CITY OF ALBUQUERQUE

March 25, 2020

**RE: Dunkin' Donuts
4208 Central SW
Temporary C.O. - Accepted
Engineer's Certification Date: 03/24/20
Engineer's Stamp Date: 07/26/19
Hydrology File: K12D015D**

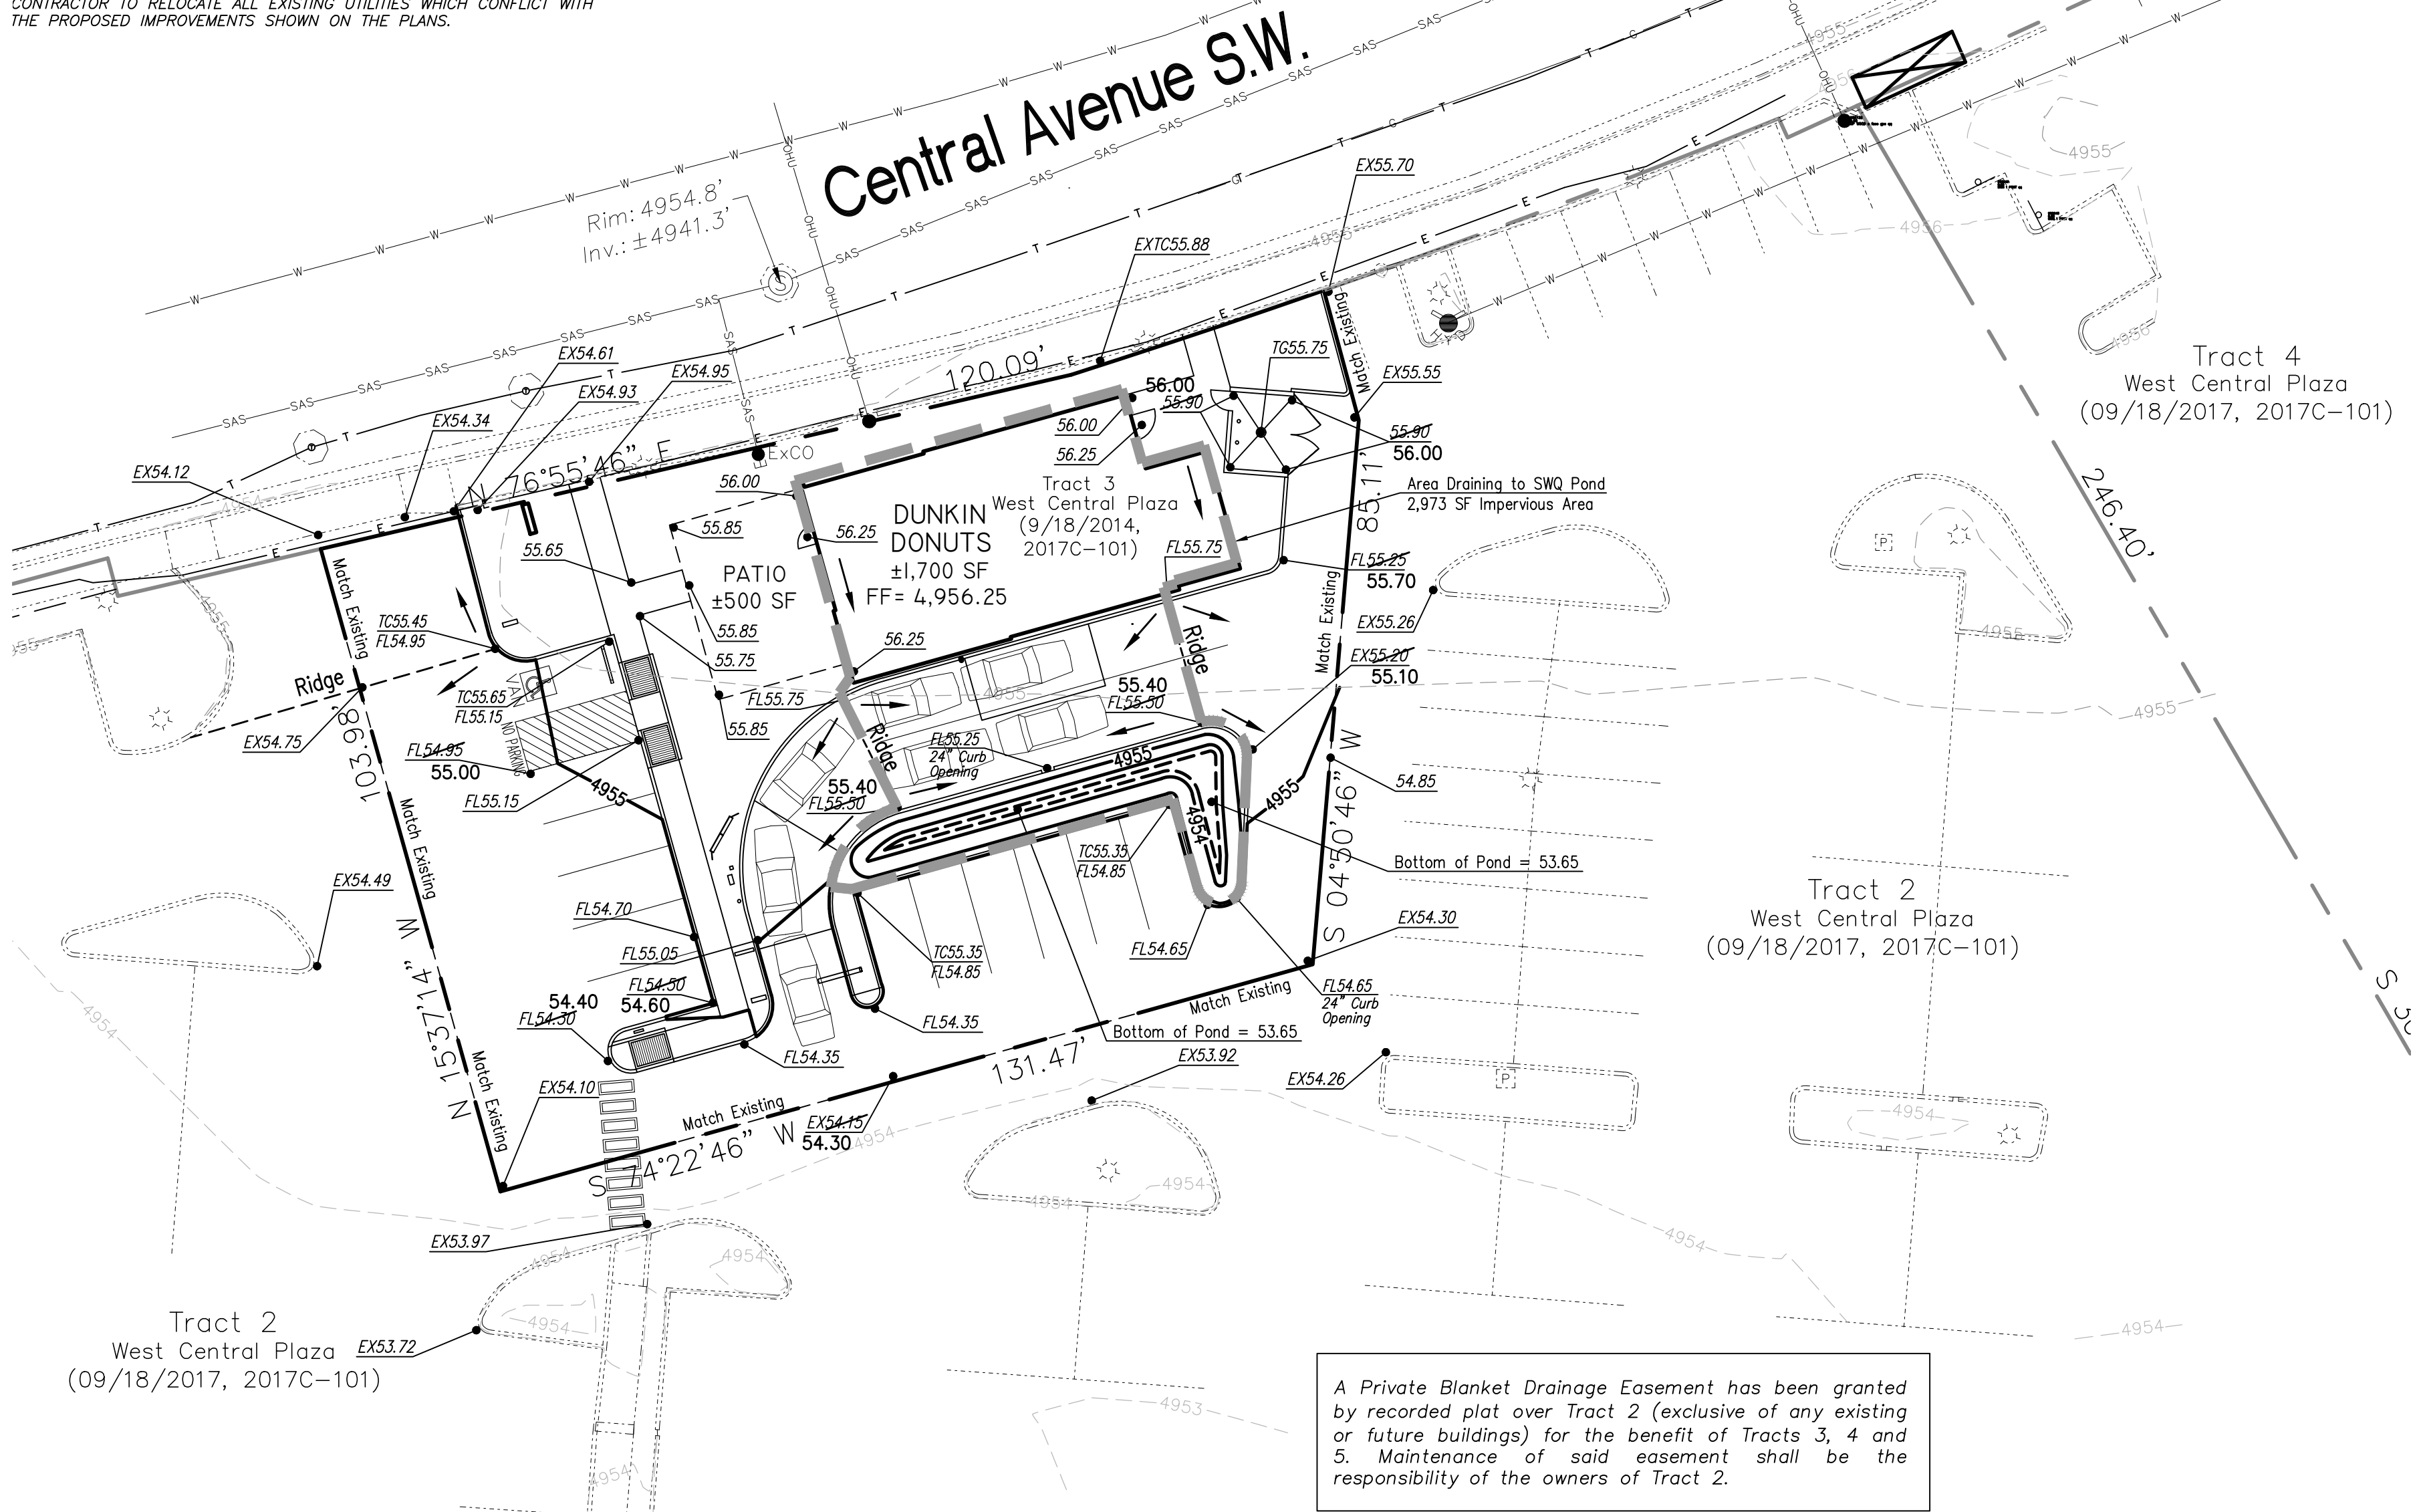
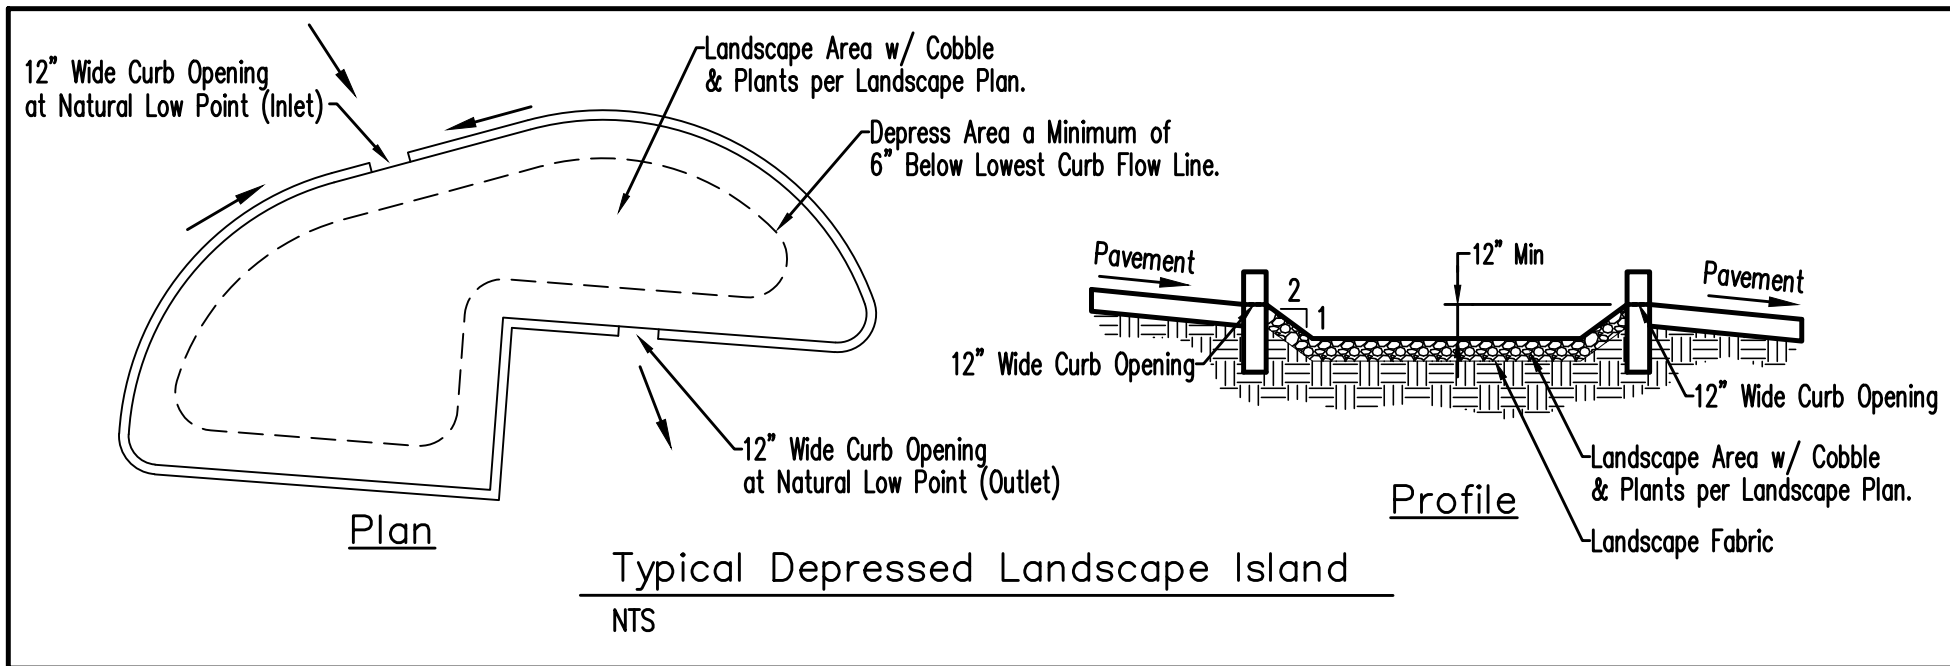
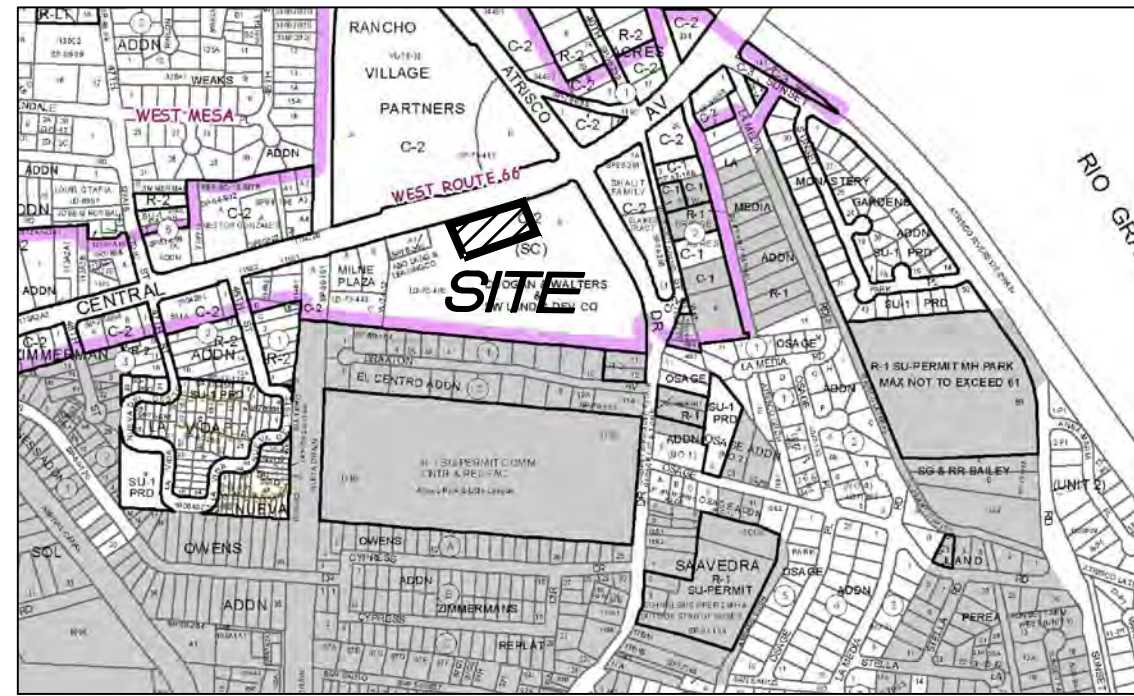
1. Please provide Drainage Covenant per Chapter 17 of the DPM prior to Permanent Release of Occupancy for the stormwater quality ponds. Please submit these to the 4th floor of Plaza de Sol. A \$25 fee for each will be required.
